From: Laura Gibbons
Sent: 09 May 2018 14:55
To: Planning.Responses
Subject: RE: Planning Consultation on BE/56/18/DOC

APPLICATION BE/56/18/DOC
NO:

Registered: 24-APR-18
Site Address: Land rear of 17 - 21 Greencourt Drive Bersted PO21 5EU

Description of Works: Approval of details reserved by condition imposed under
BE/138/16/OUT relating to condition 5-surface water drainage.

Client
Matt Lush
Drawing Title
Drainage Layout

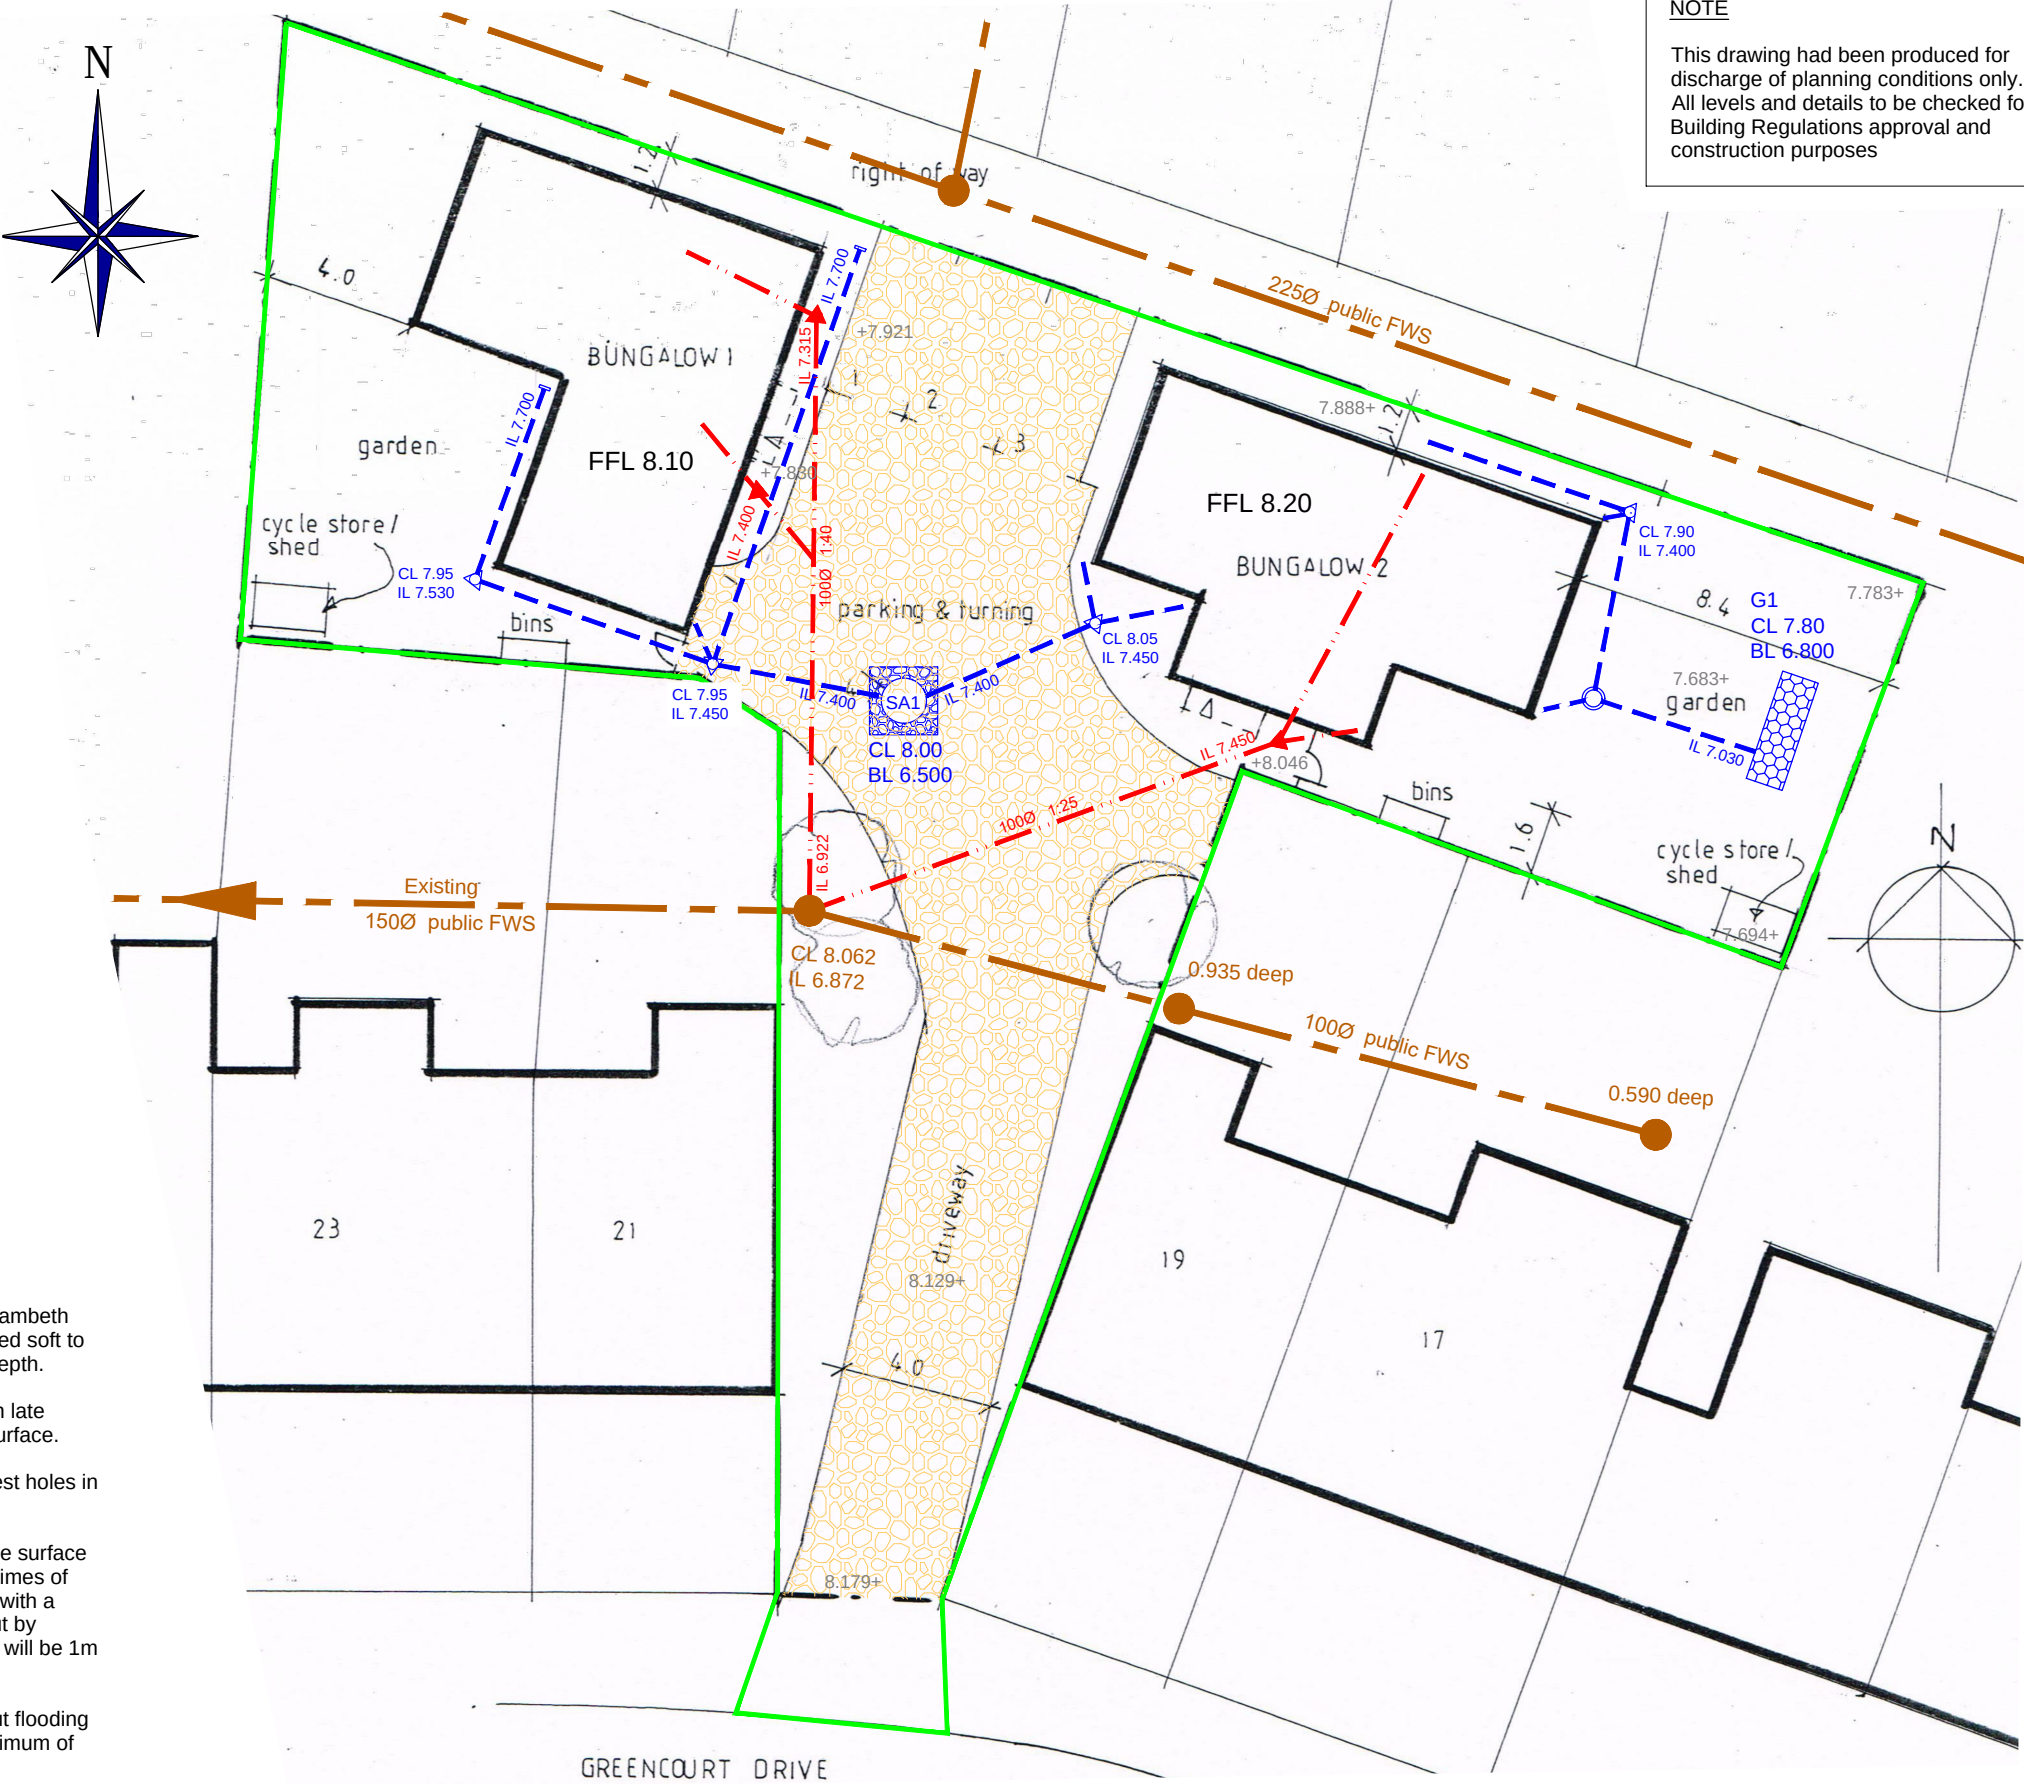
The proposed geocellular soakaway in the rear garden is proposed to be formed of 400mm deep geocells. The calculations show a maximum water depth of 421mm. Please increase the plan area of the soakaway to ensure modelled water depth is less than 400mm.
